# FOURSQUARE AT STERLING RANCH EAST FILING NO. 1

## UTILITY CONSTRUCTION PLANS

NOVEMBER 2022

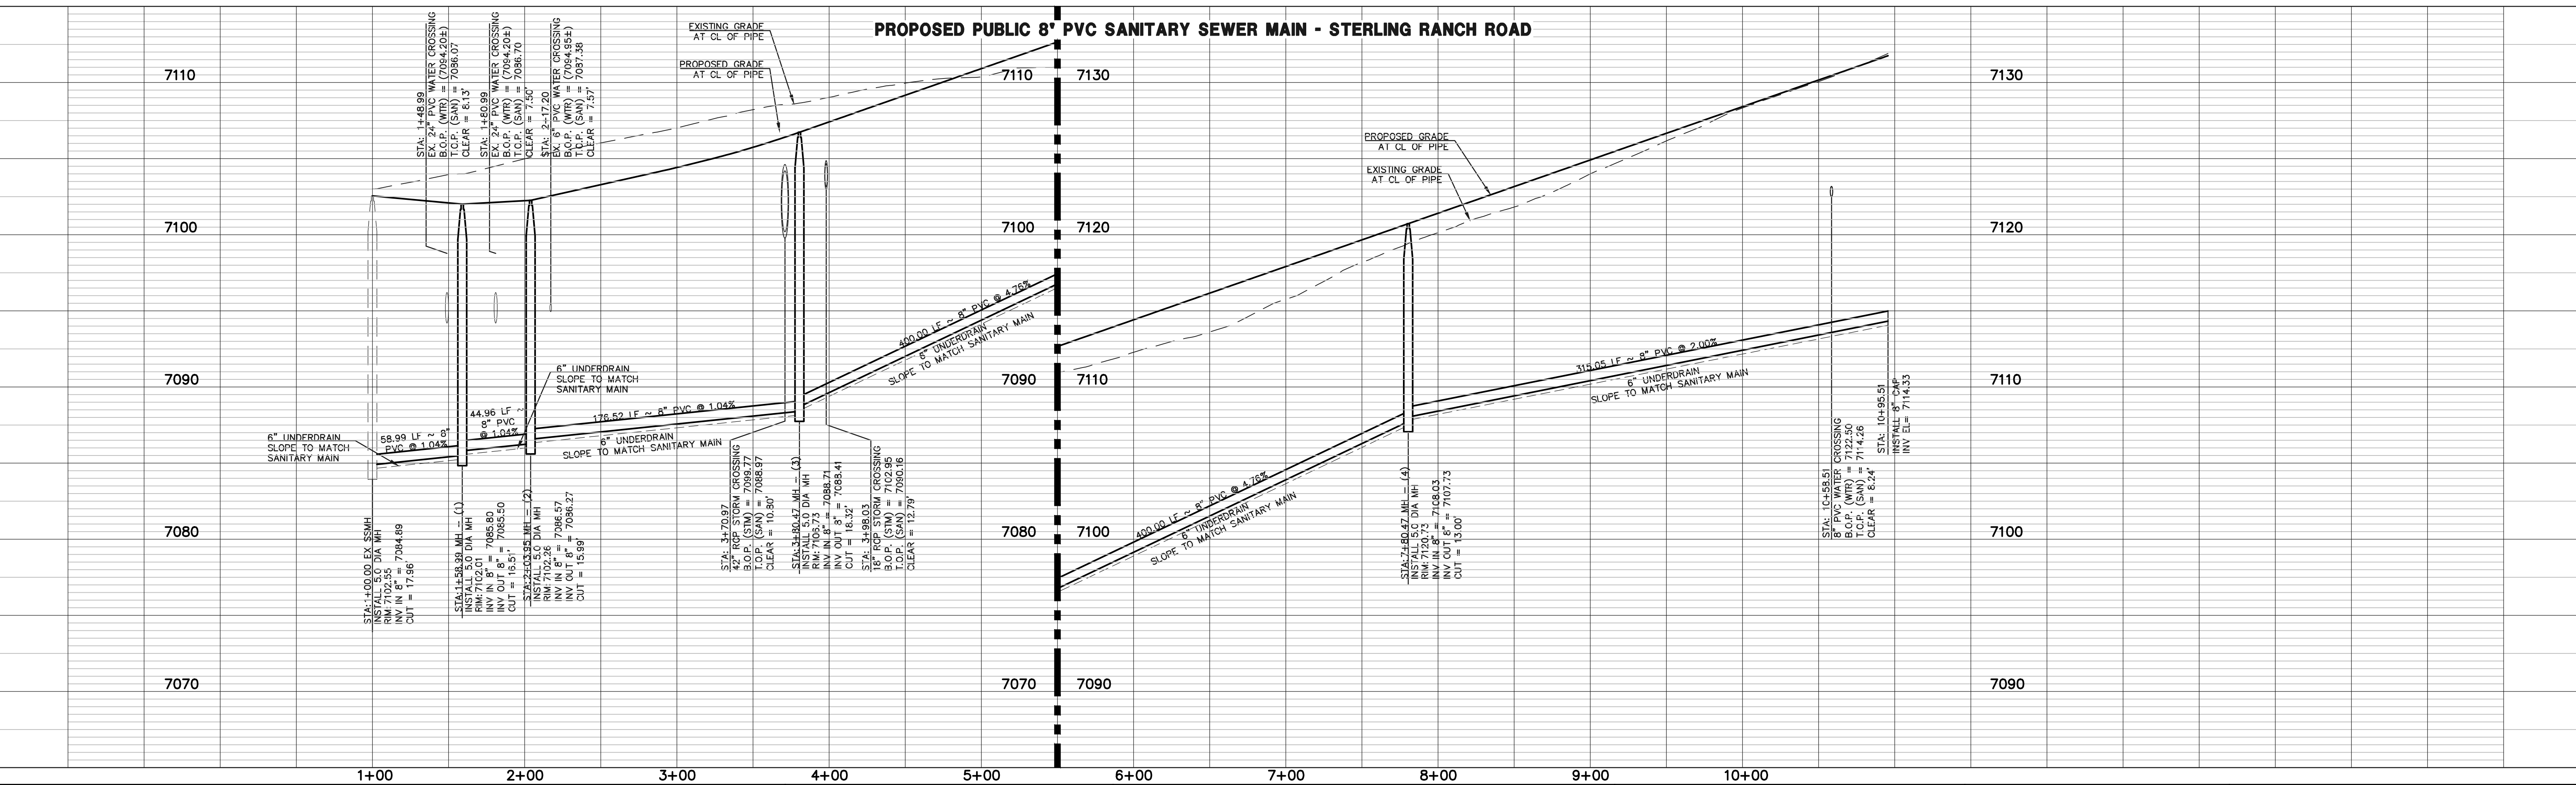
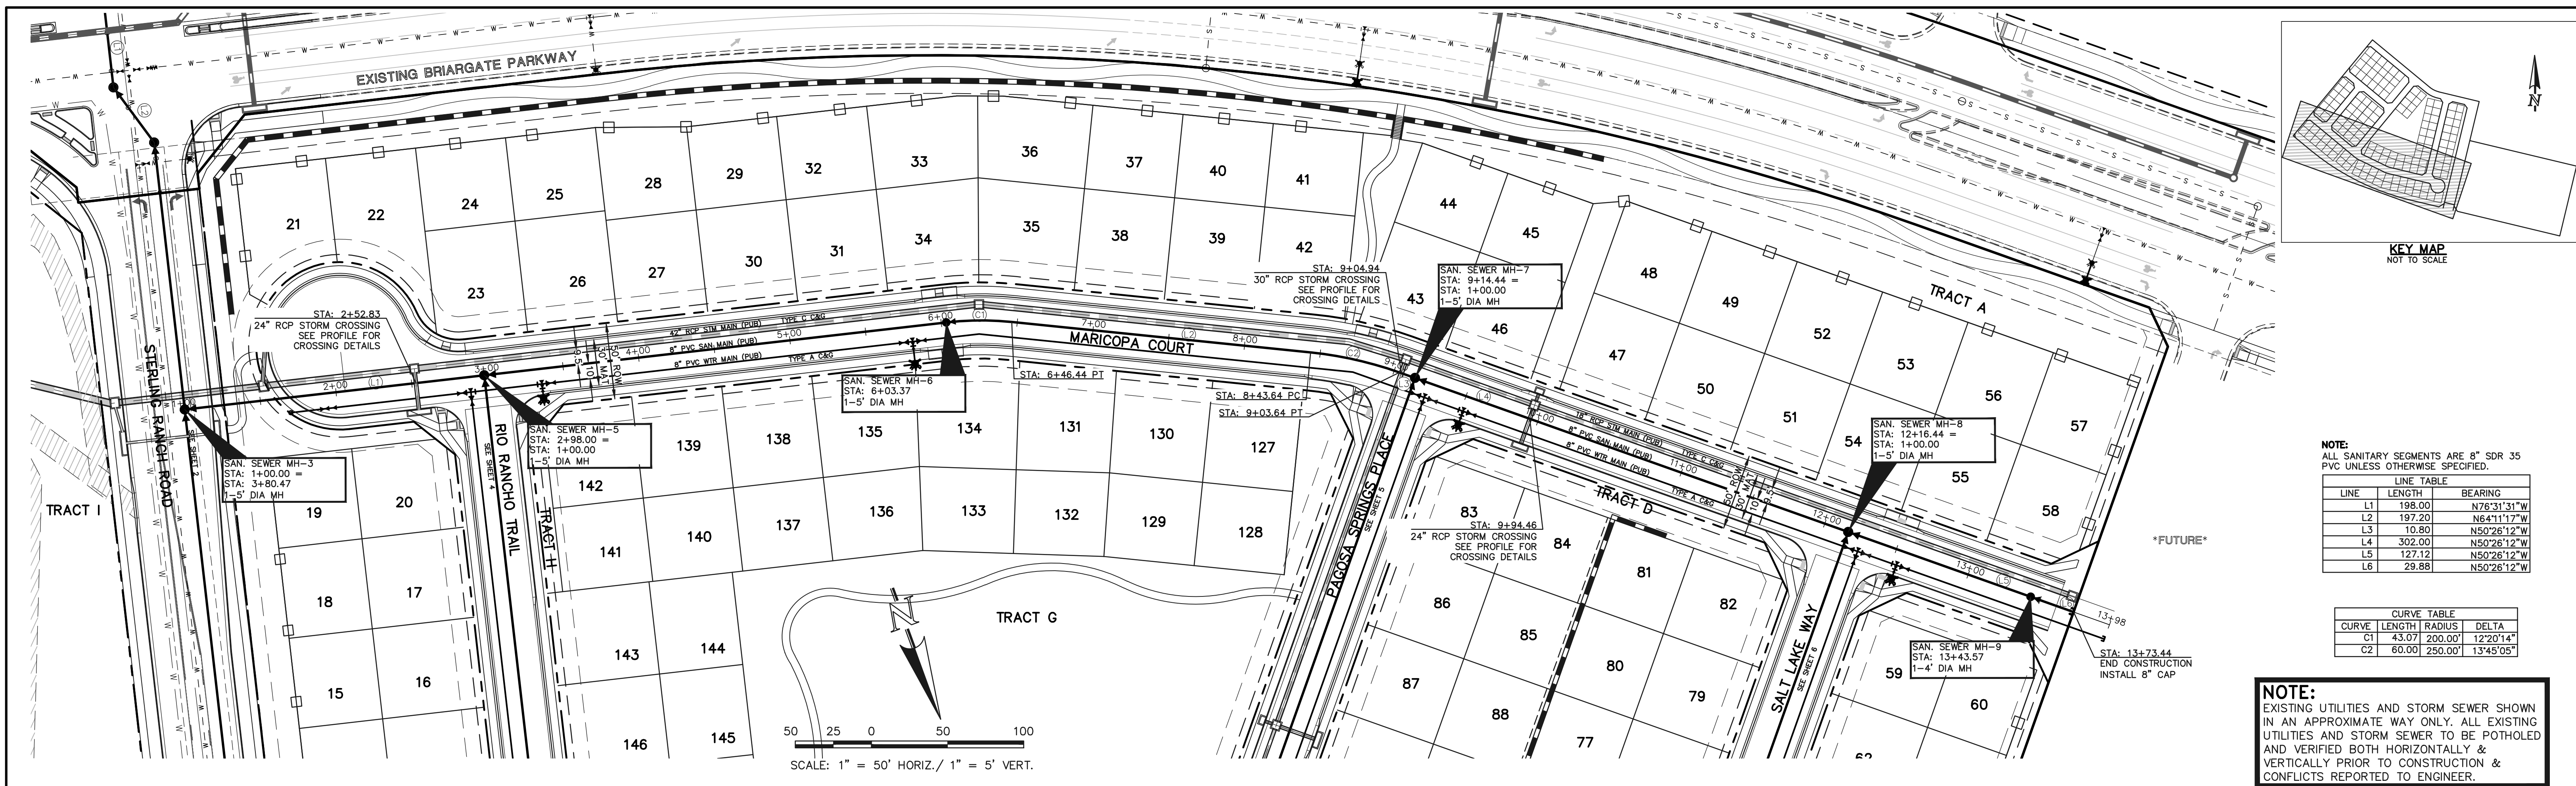
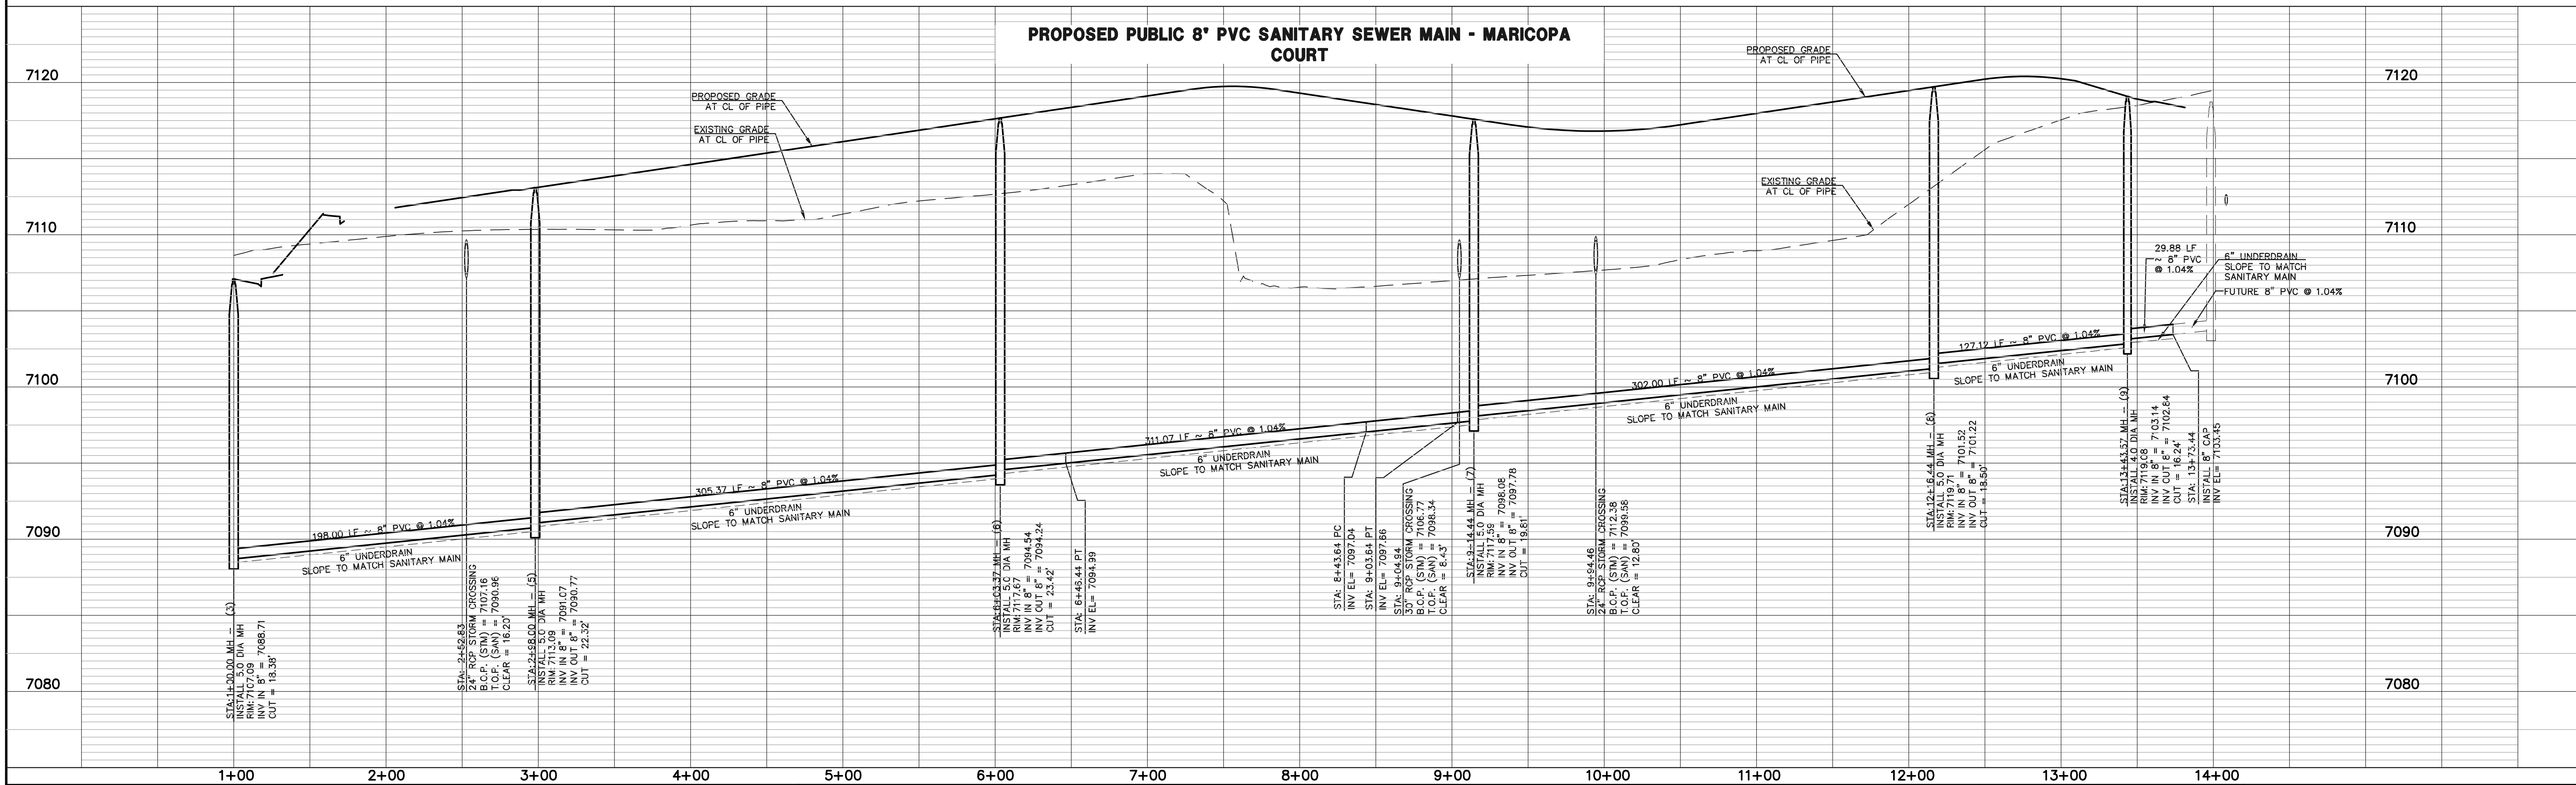
Highlighted items do not match between plan and profile (all sheets)

Plan does not show a storm crossing at this location. Remove from profile or show and label in plan view.
